17th October 2023

**TOWN AND COUNTRY PLANNING ACT 1990 NON-MATERIAL AMENDMENT PLANNING TO APPROVAL
22/01144/F OS Parcel 5700 South West Of Grange Farm, Street Through Little Chesterton,
Chesterton.**

Since the application was approved, the occupier (Siemens Healthcare Ltd) has been refining the proposed plans in order to ensure the built-out scheme meets their detailed operational requirements. This has necessitated a number of minor changes to the external and internal appearance of the building. The table below sets out the changes that are required.

Drawing Name:  
ENHANCED - Phase 1 - Roof Plan

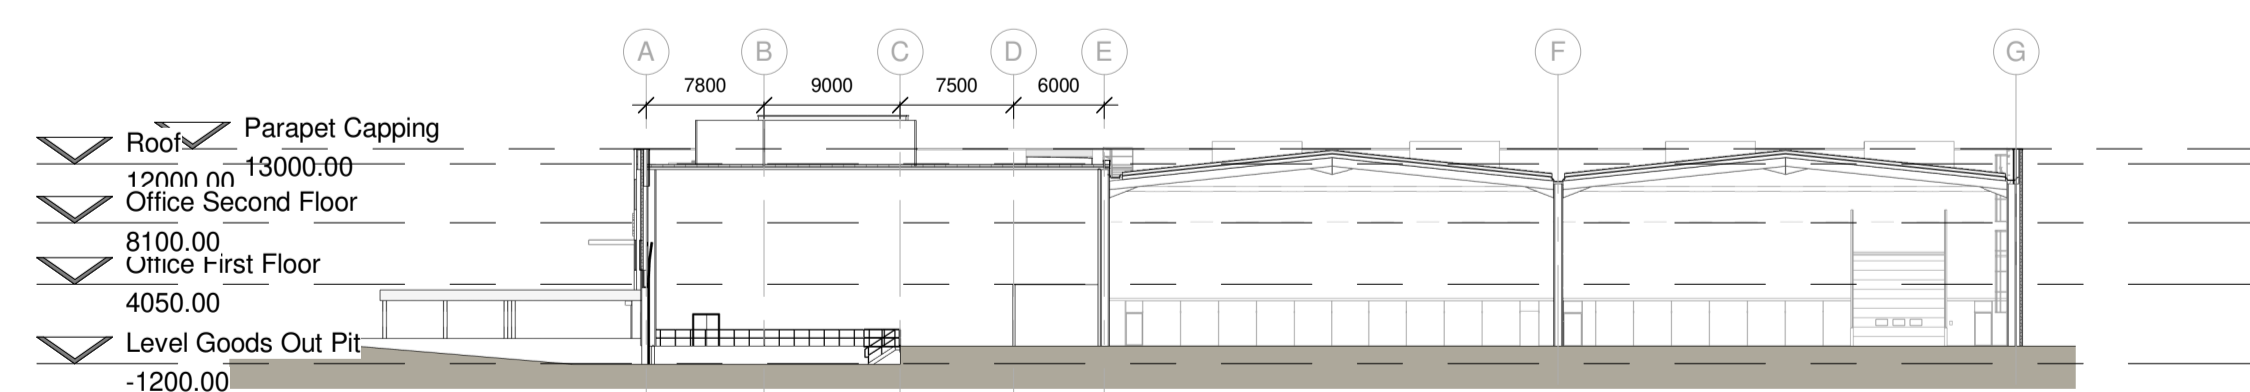
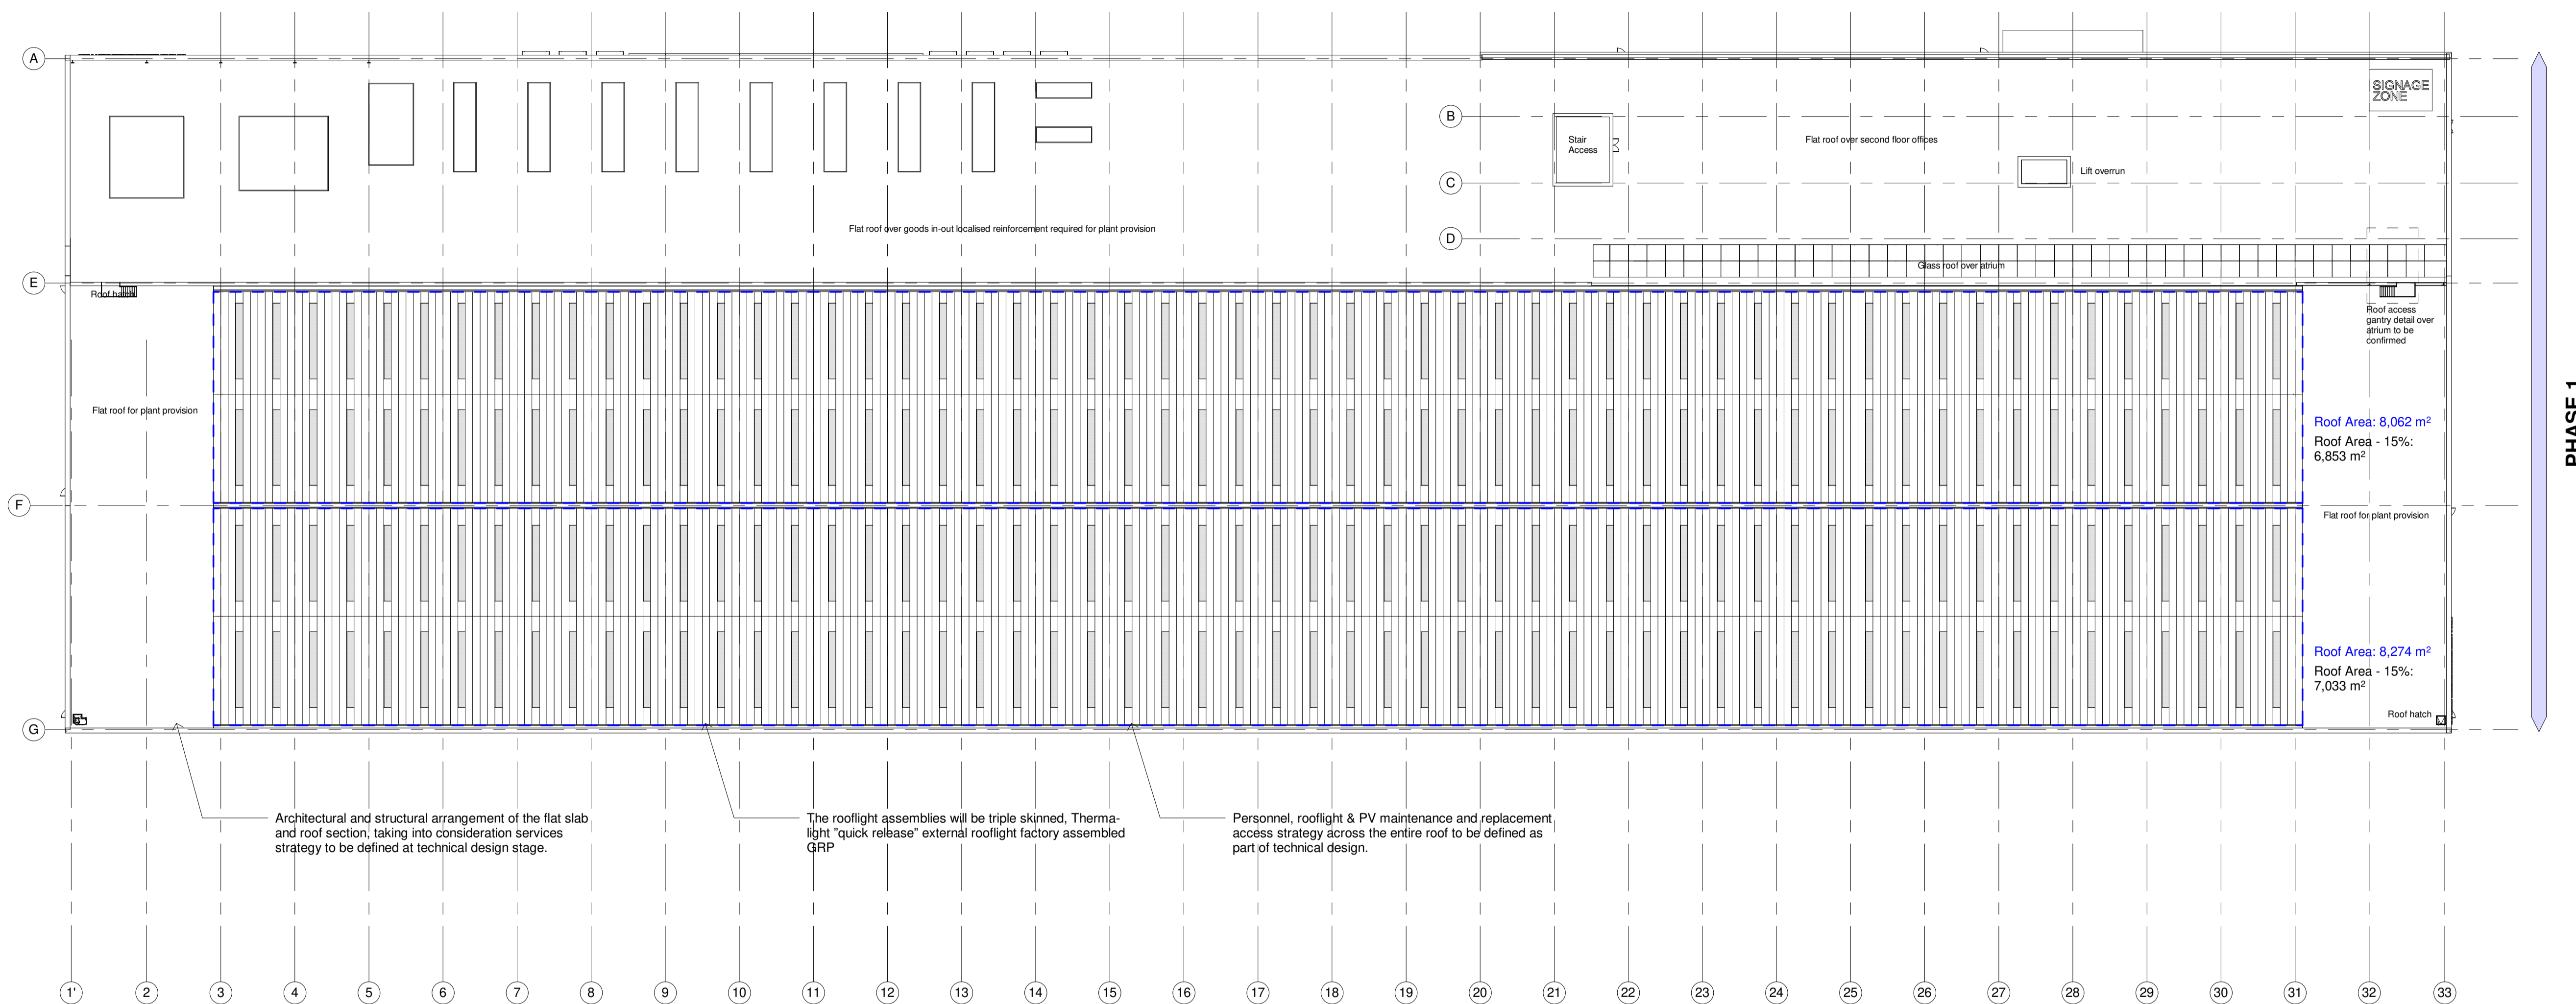
Rationalisation of services/plant equipment on the roof.	Siemens have been reviewing the approved design and operational performance of the production facility and how to maximise operational floorspace. Plant and services extrusions have been concentrated into focused areas, and where these protrude from the roof they will be visually enclosed in a reduced number of plant rooms and service kennels to rationalise operational requirements and minimise visual clutter. The maximum height of the plant rooms does not exceed the maximum height of the 16.15m fall protection railing currently approved. There is however a lift overrun measuring 3.9m x 4.9m in size that has an overall height of 17.40m.	Phase 1 Roof Plan 13-222-SGP-ZZ-ZZ-DR-A-131109 Rev G.	Roof Plan 13-222-SGP-01-ZZ-DR-A-201155 P01.

Drawing Number:
13-222-SGP-ZZ-ZZ-DR-A- 131300
Project Code Originator Volume Level Type Role Number

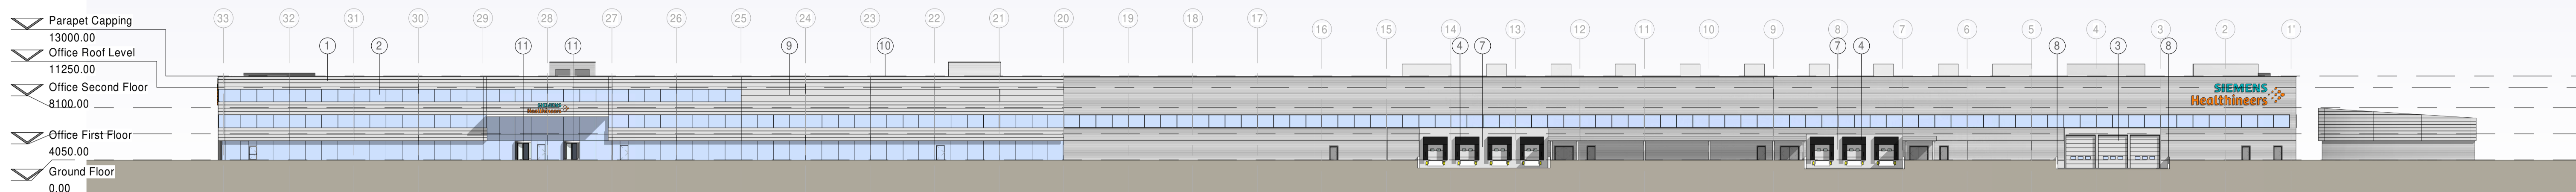
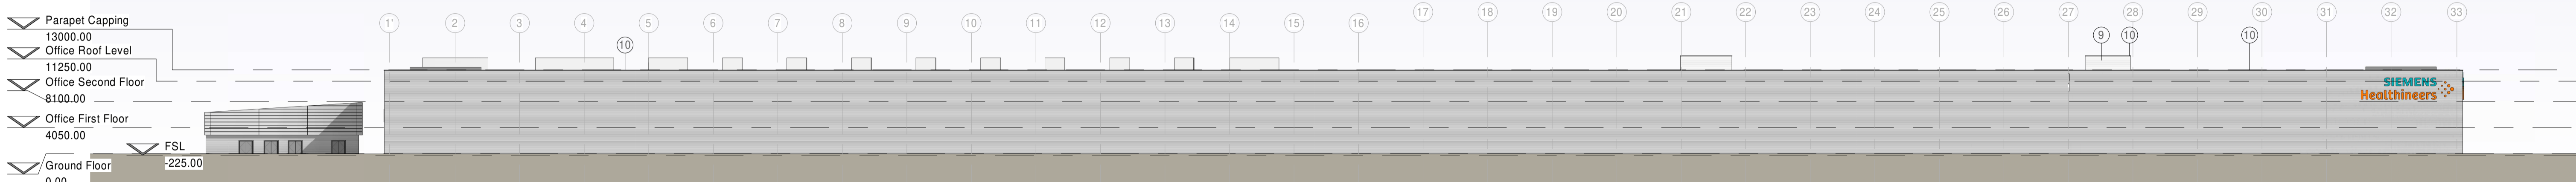
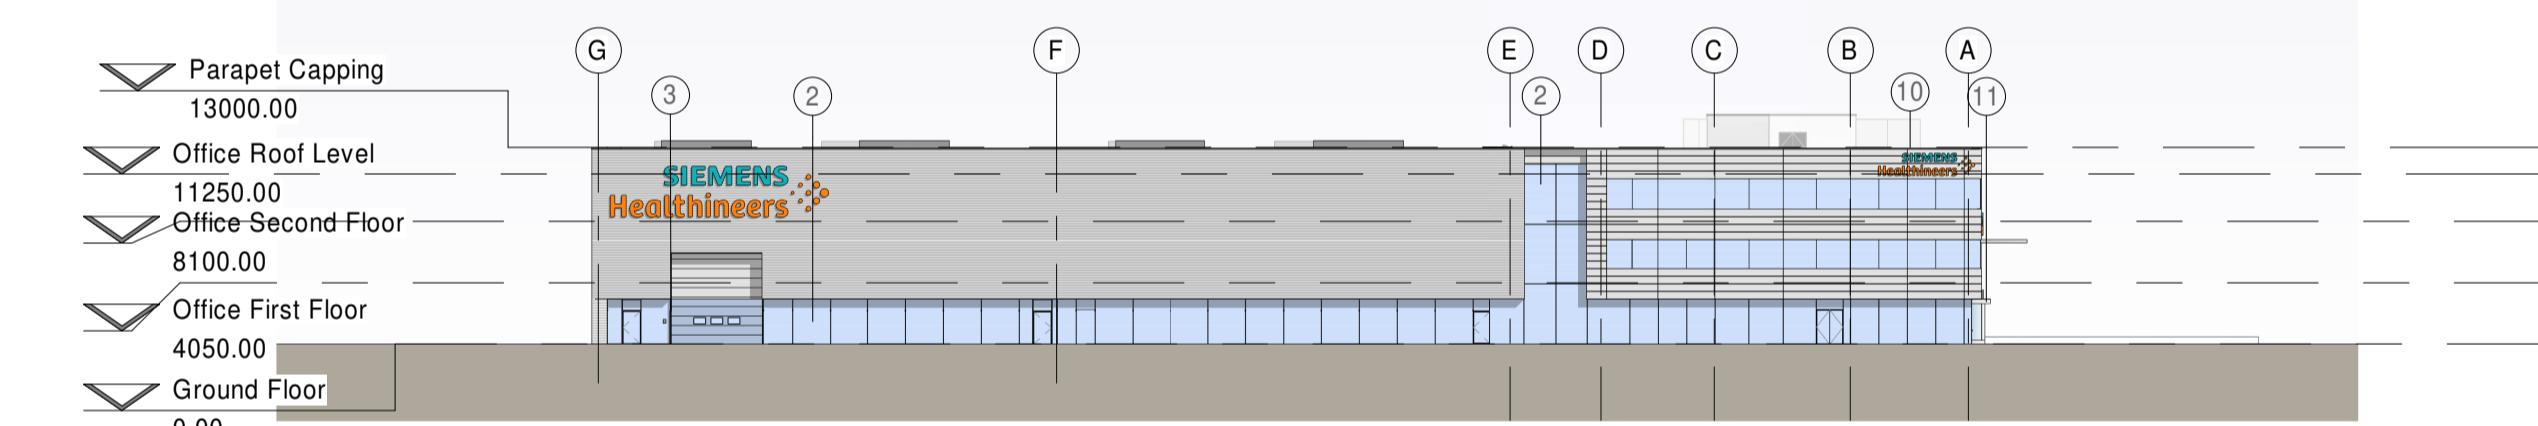
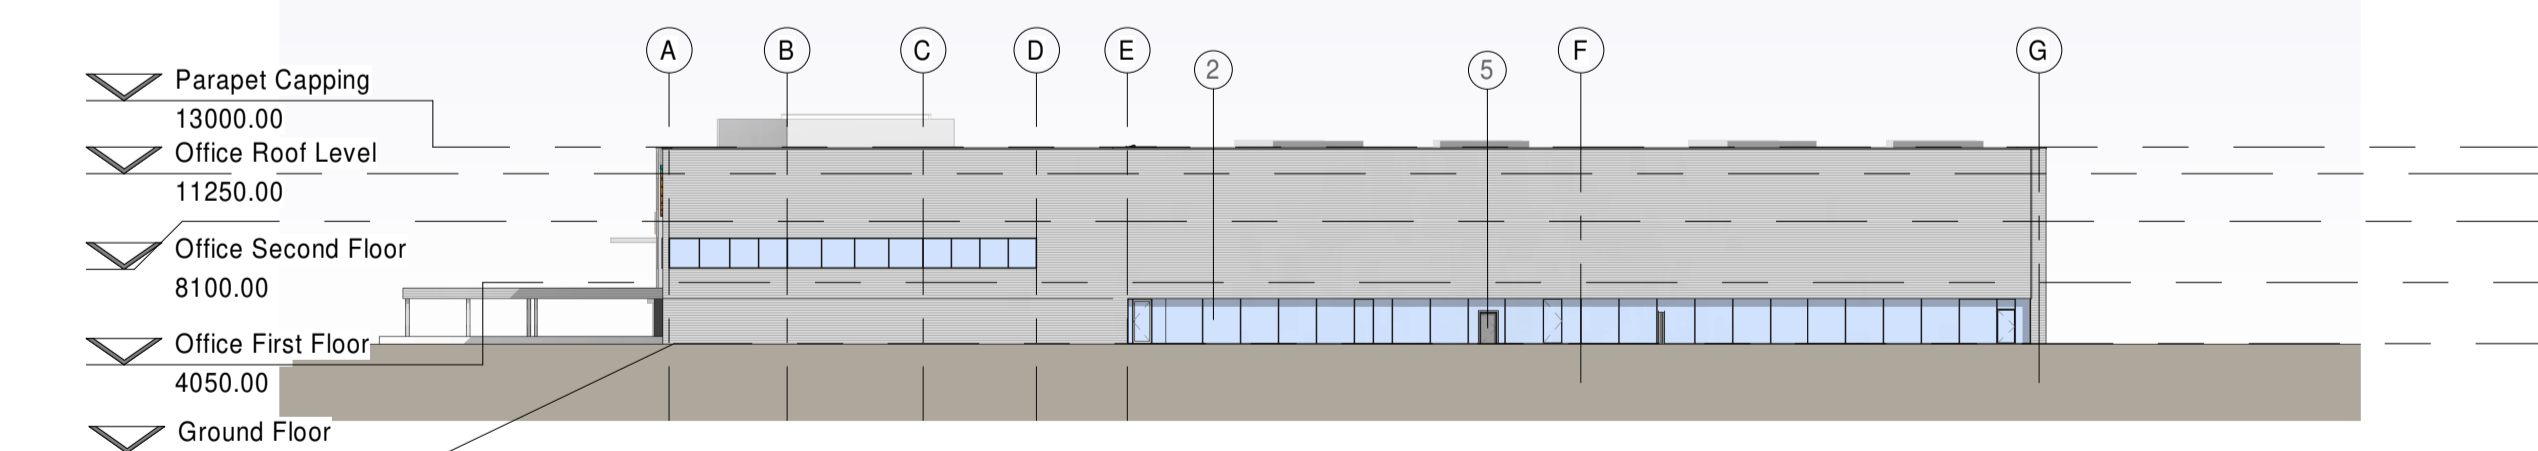
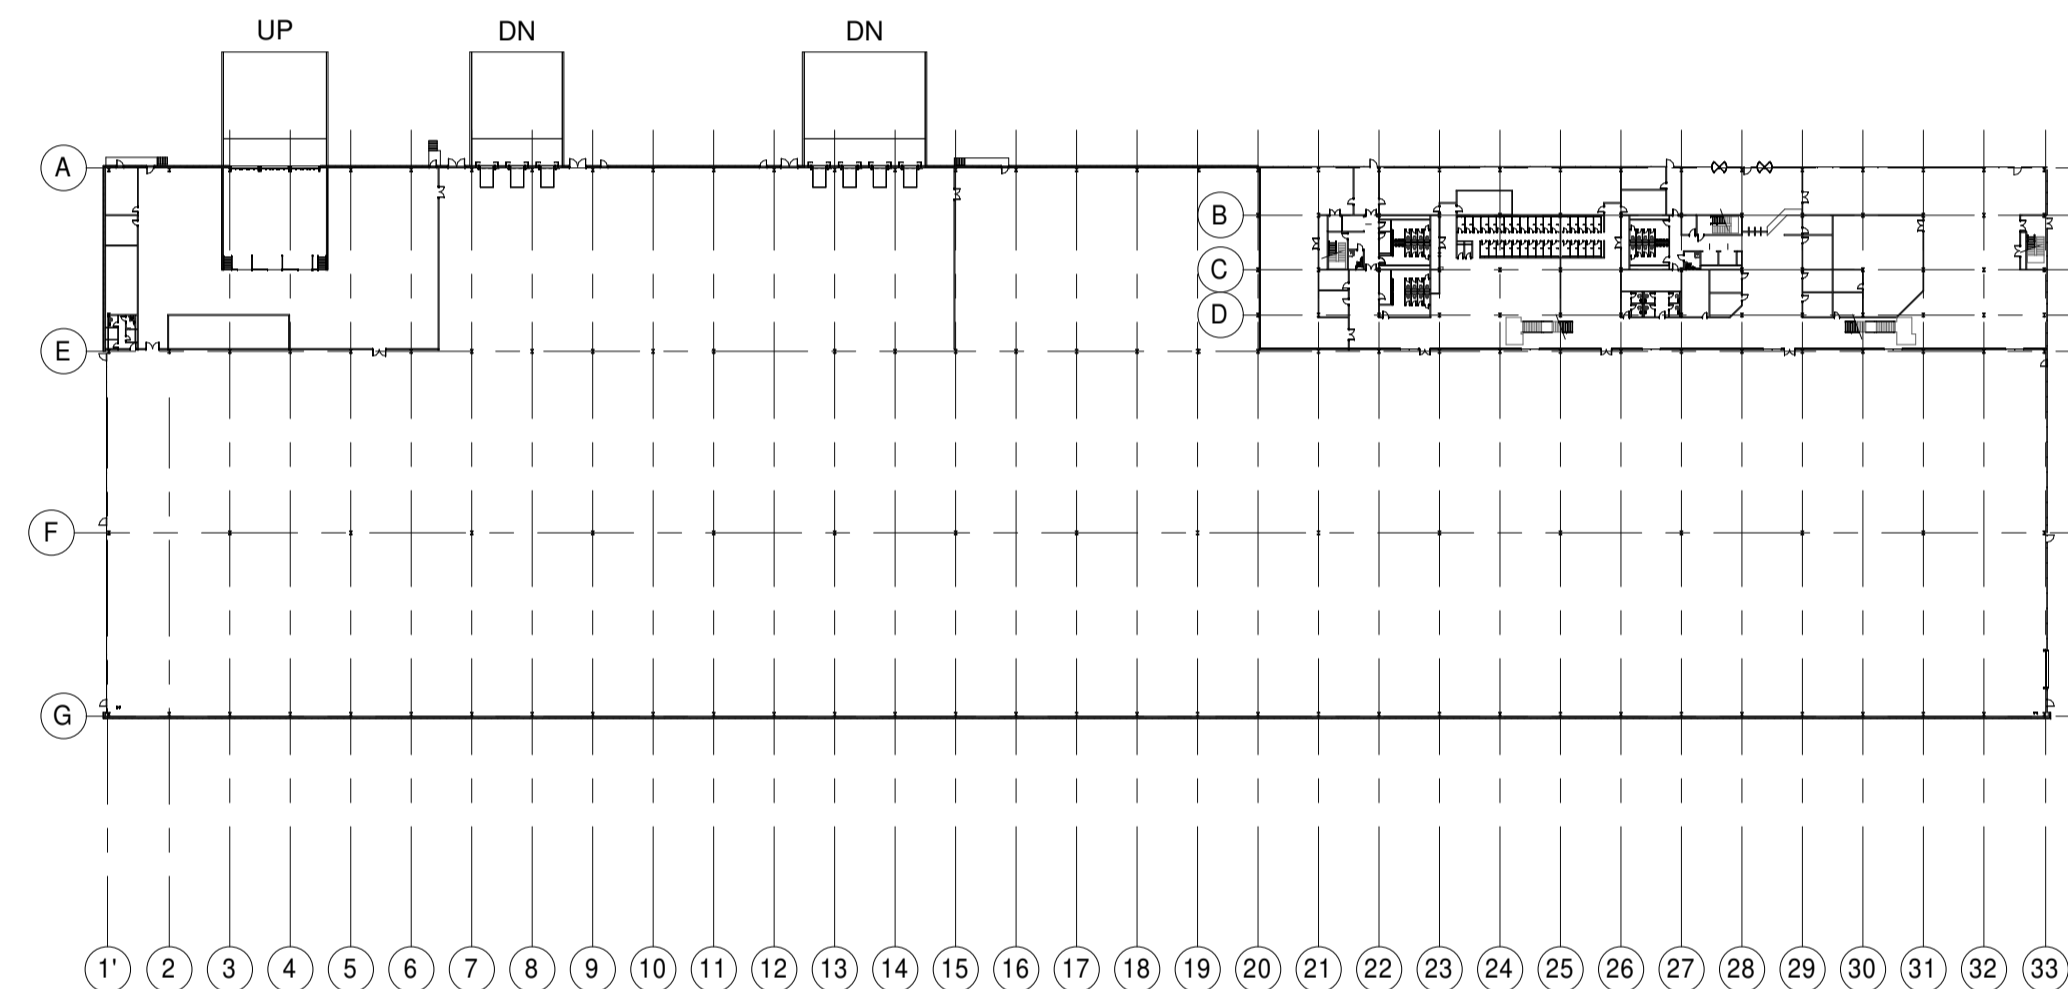
External Finishes Plan Phase 2. Drawing no. 13-222-SGP-ZZ-ZZ-DR-A-131002 REV M	External Finishes Plan Phase 2. Drawing no. 13-222-SGP-ZZ-ZZ-DR-A-131002 REV N.
Minor variations to Elevational Details.	<p>A number of minor revisions to various elevations are proposed:</p> <p><u>North East Elevation:</u></p> <ul style="list-style-type: none">• Replace built up system with composite cladding panels.• Glazed windows added to Second Floor Offices and Goods in Office.• Relocation of 1 x revolving door• Repositioning of doors/Addition of Roller doors <p><u>South West Elevation:</u></p> <ul style="list-style-type: none">• 6 x new external doors added. <p><u>South East Elevation:</u></p> <ul style="list-style-type: none">• Repositioning of doors/Addition of Double doors. <p><u>North West Elevation:</u></p> <ul style="list-style-type: none">• Repositioning of doors/Addition of Double doors.	Phase 1 Elevations 13-222-SGP-ZZ-ZZ-DR-A-131300 Rev E	Elevations 13-222-SGP-500-EL-D-A-121351 Rev P01.
